February 28, 2020

Timberland

9027 SE 60<sup>th</sup>. ST.

2001-170

**A10**

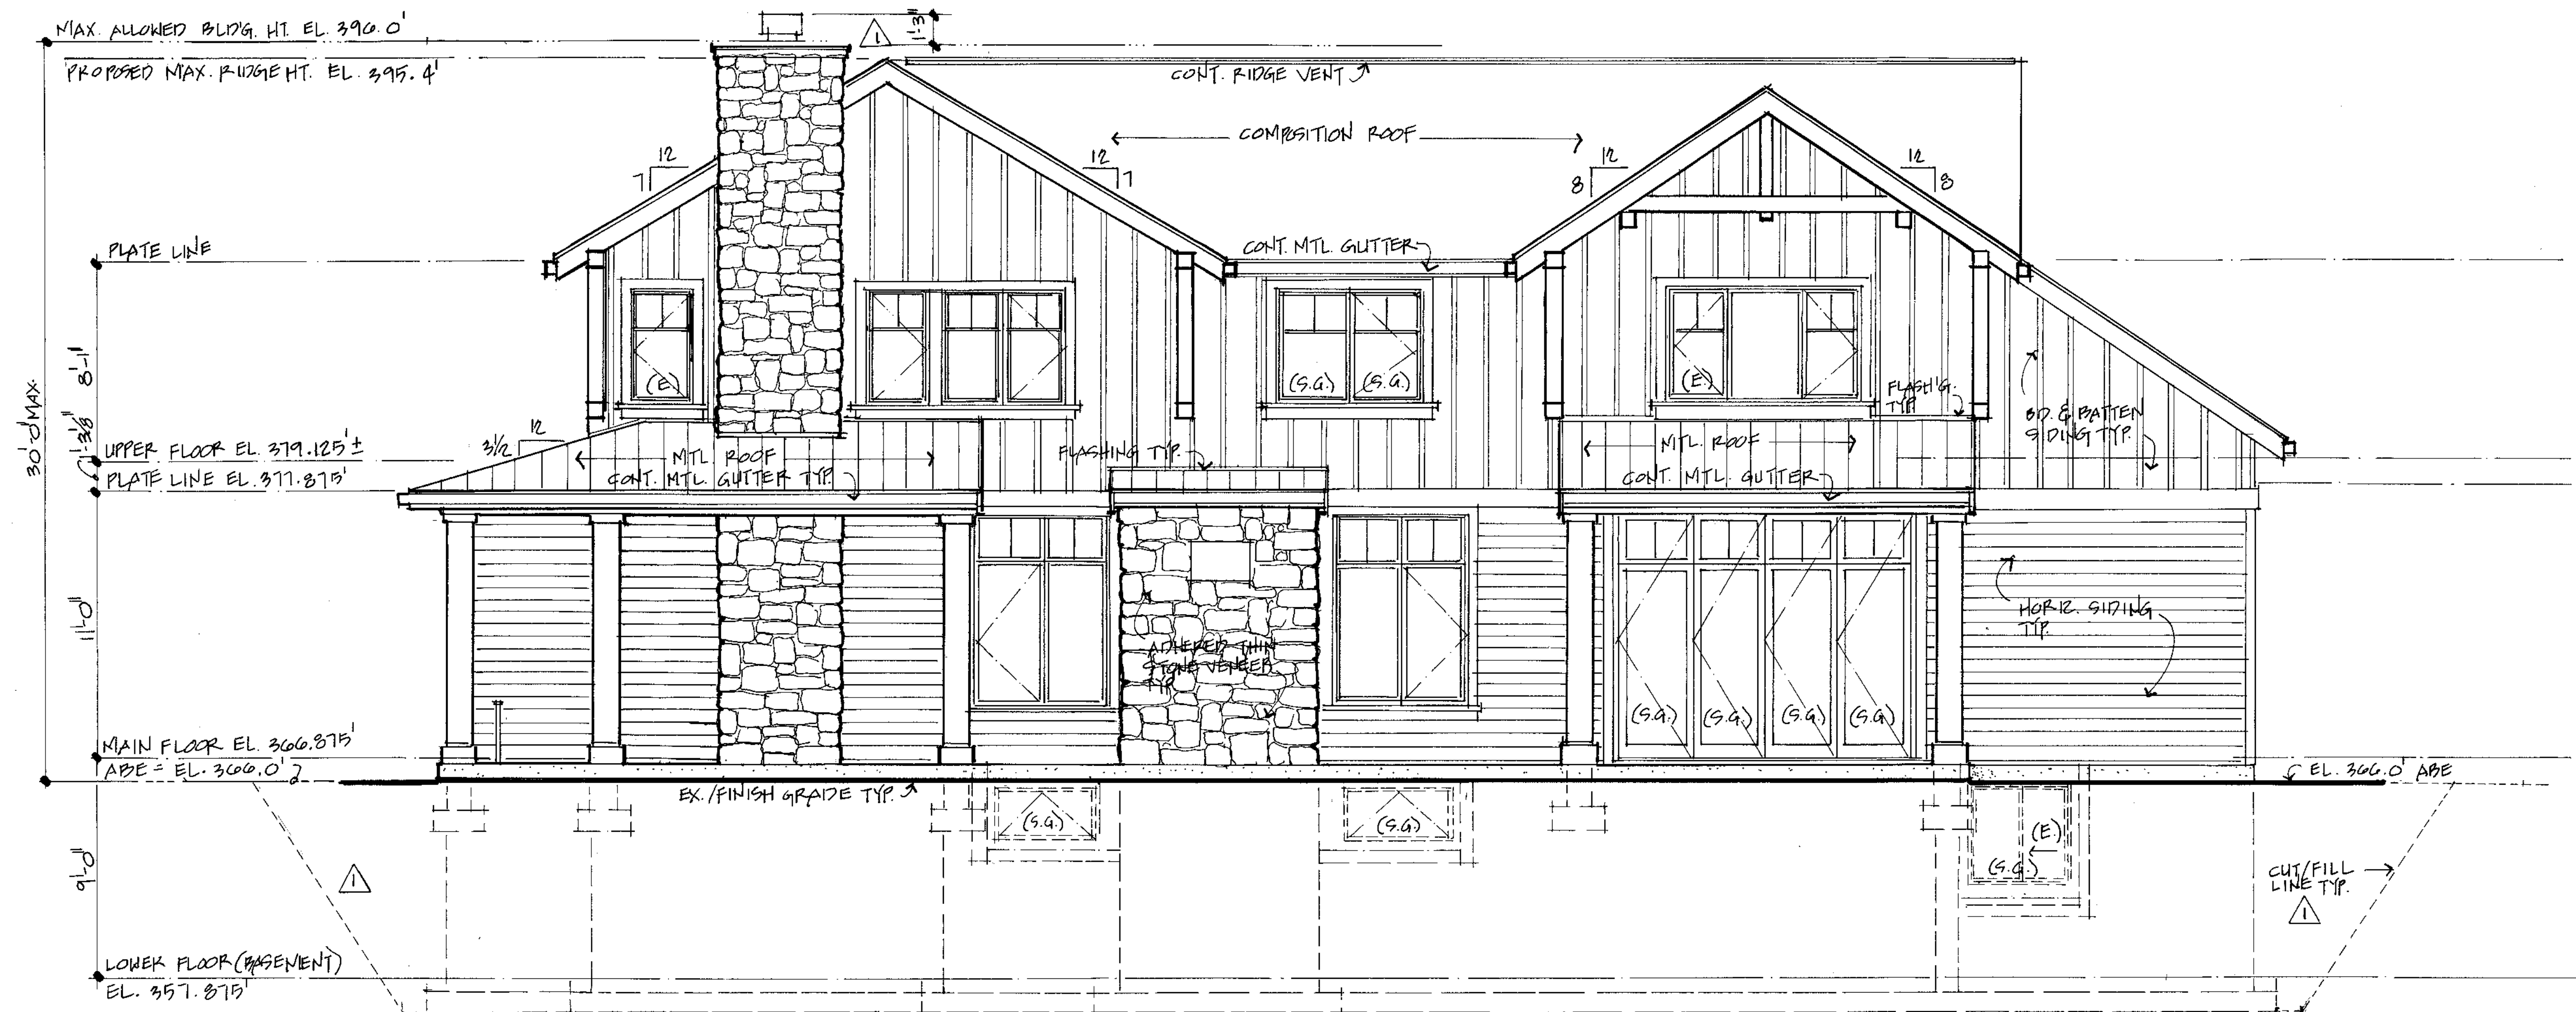
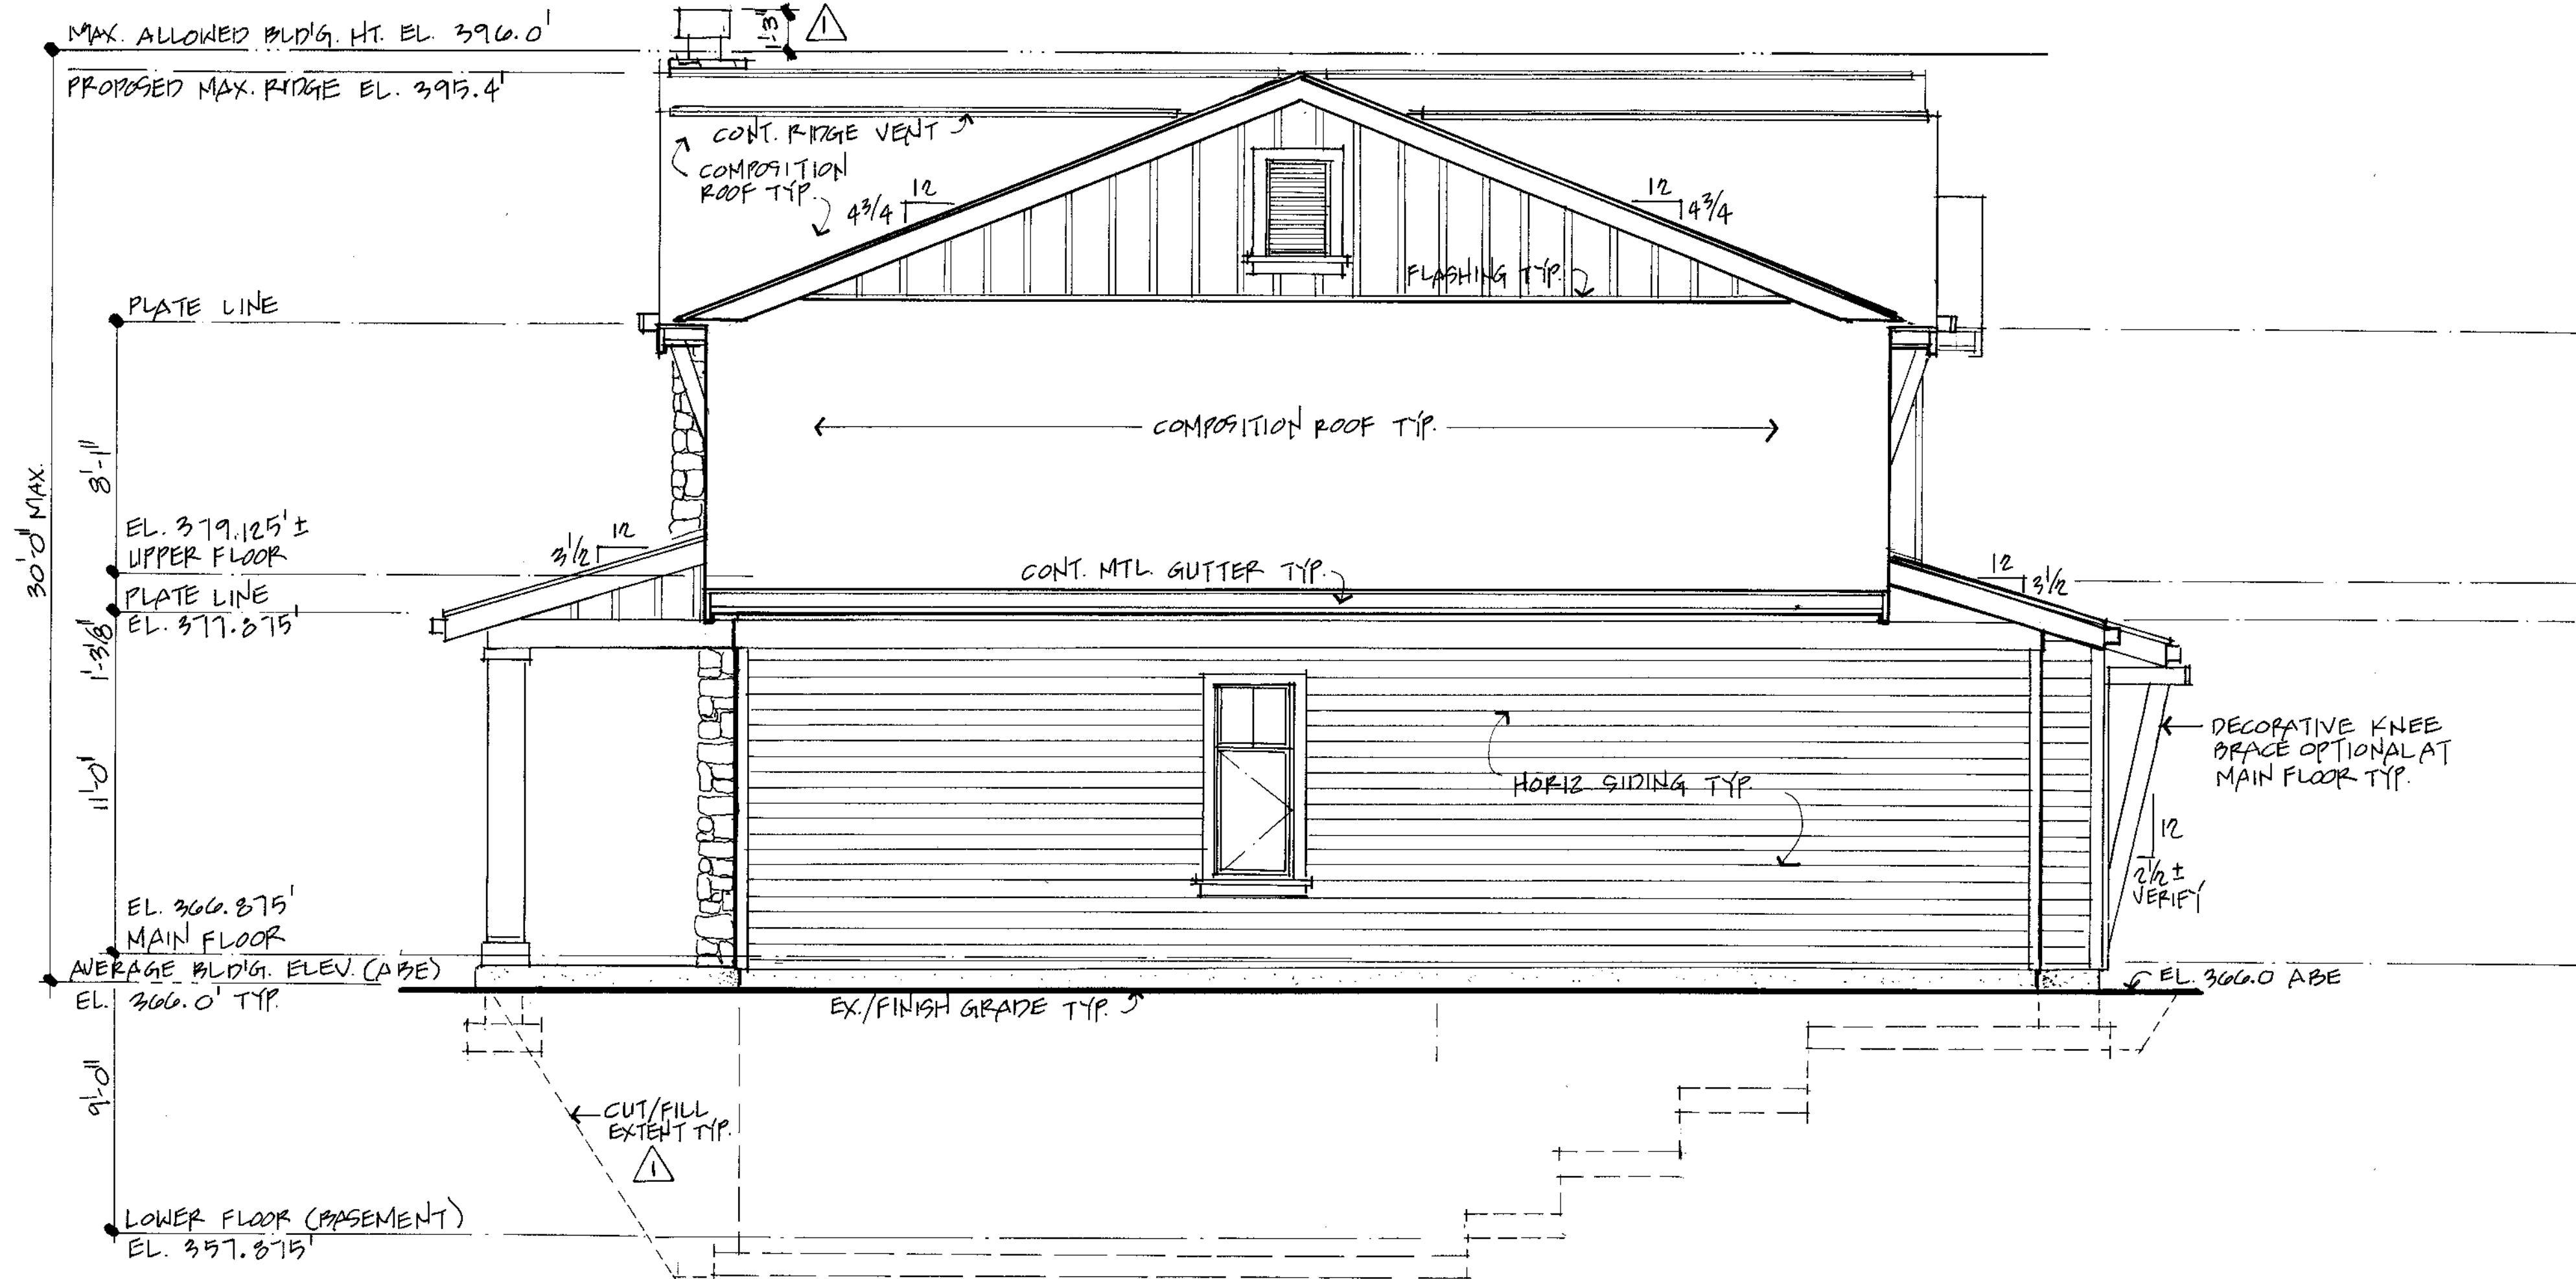
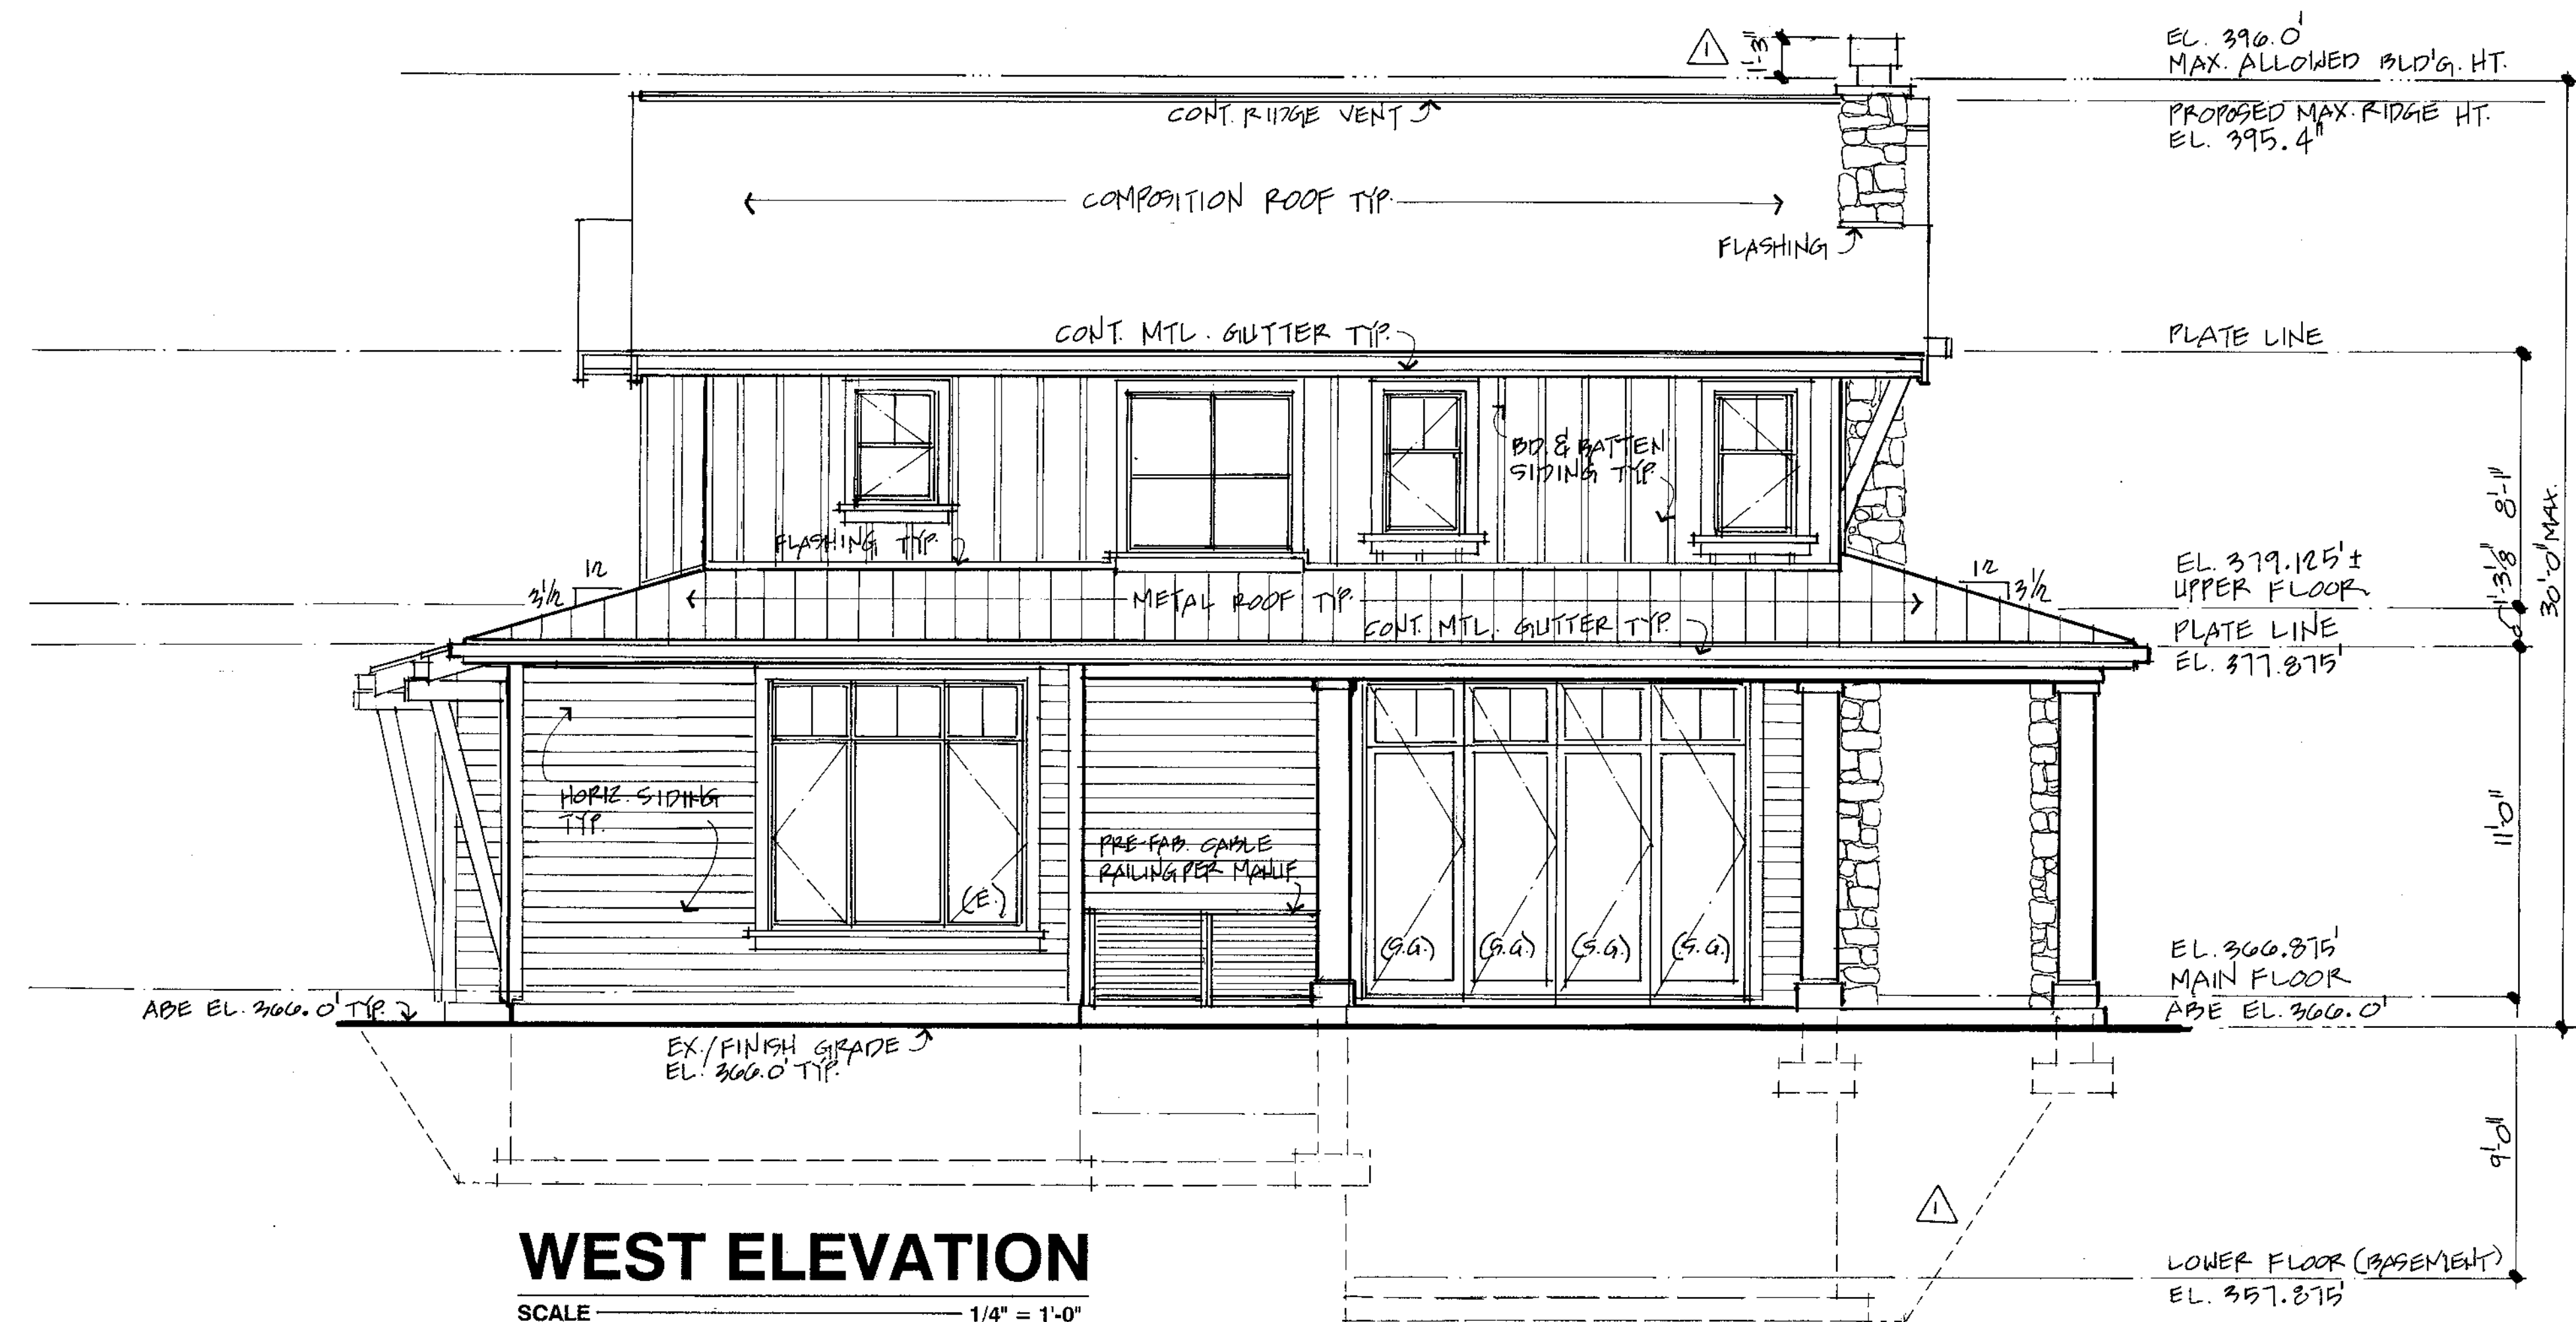
Added appurtenances height (chimney height) to Elevations sheets A10 & A11.

Added grading limits outside building footprint sheets A10 & A1, amount shown on sheet A1.
